Our Ref: FG/42/20/HH
Your Ref:

Town & Country Planning Act 1990 (as amended)
Town & Country Planning (Development Management Procedure) (England) Order 2015
Application for Planning Permission for Works or Extension to a Dwelling

Development Demolition of existing garage and erection of single storey side & rear extension
Location 41 Sea Lane Gardens Ferring

Block plan

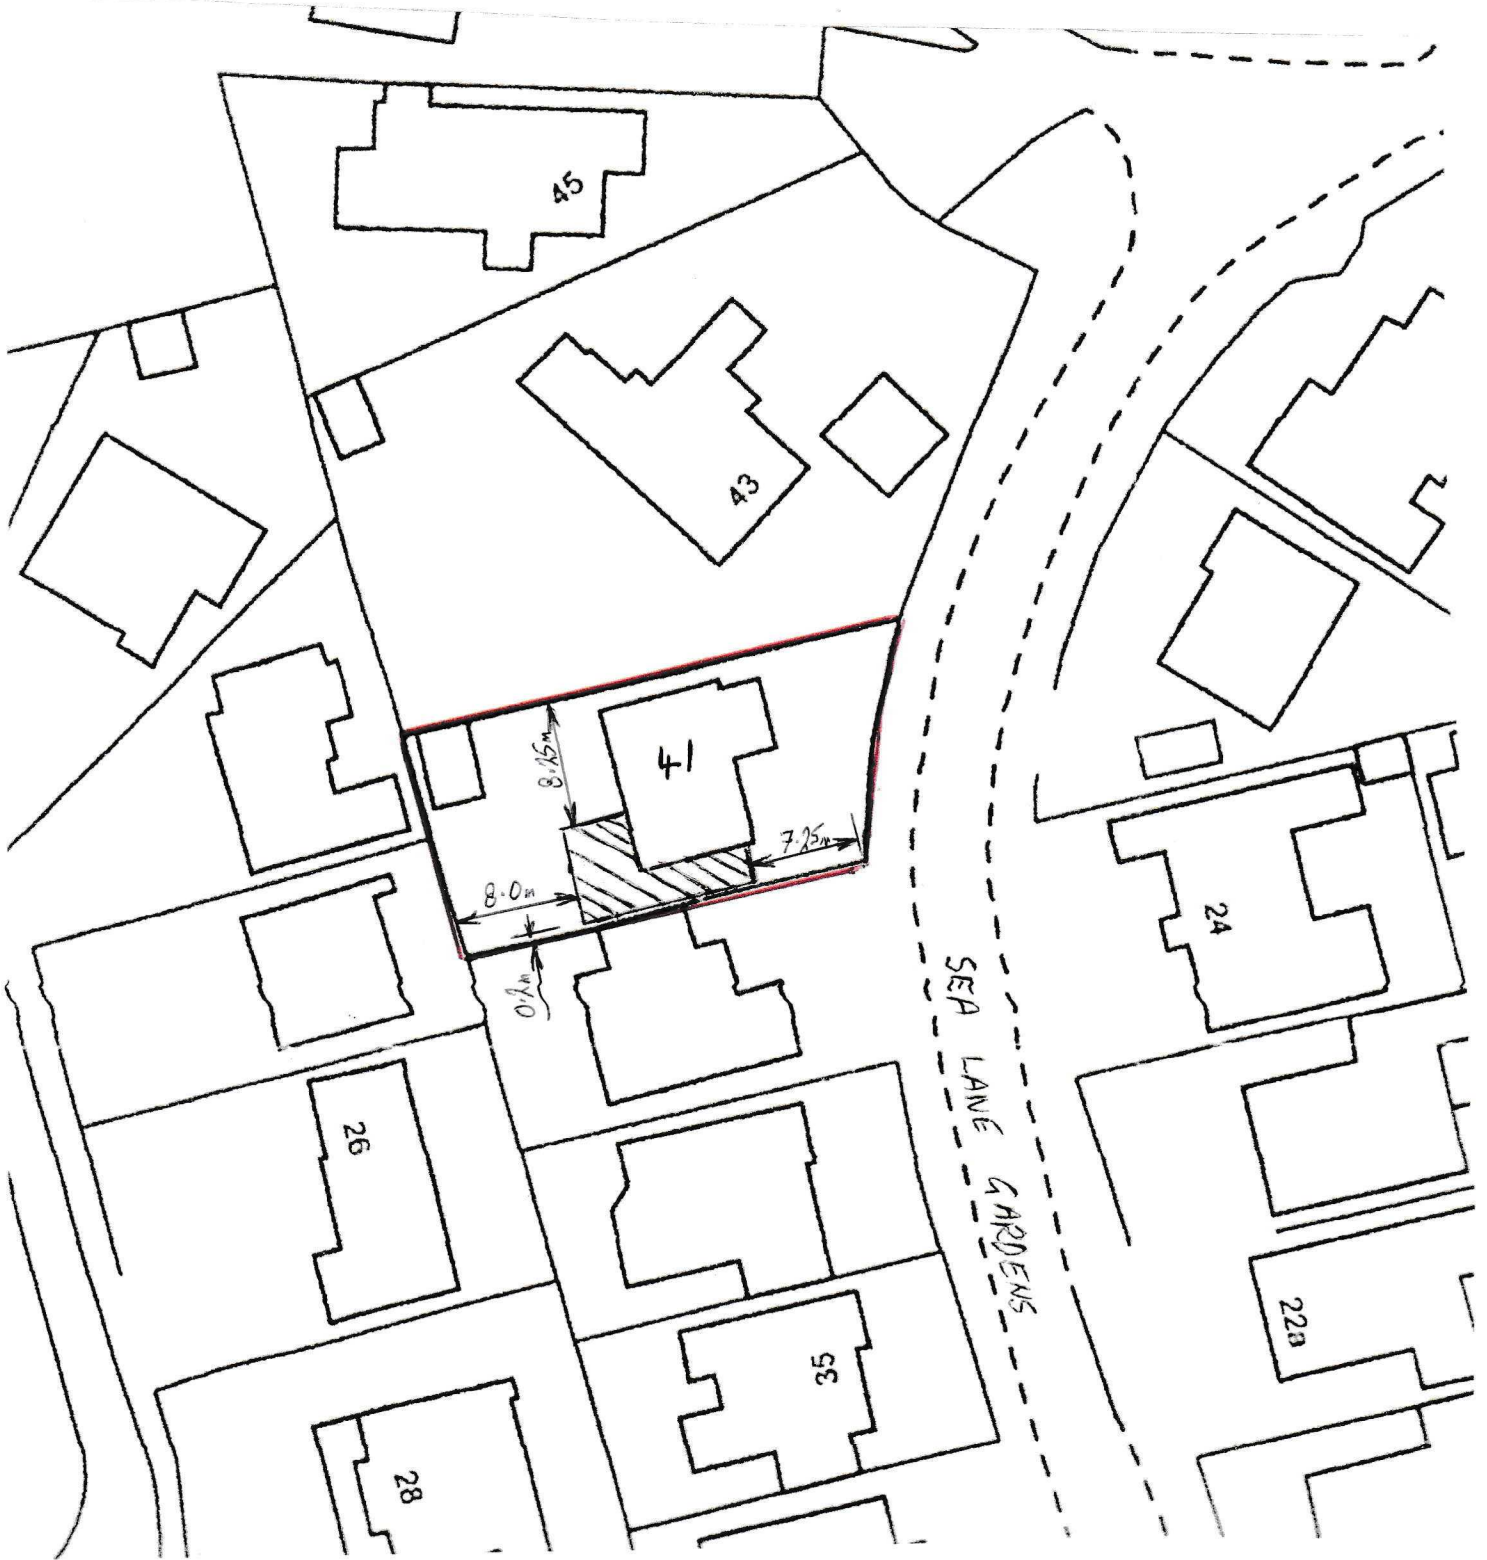
Block Plan: You are required to include dimensions from the proposed extension to all site boundaries.
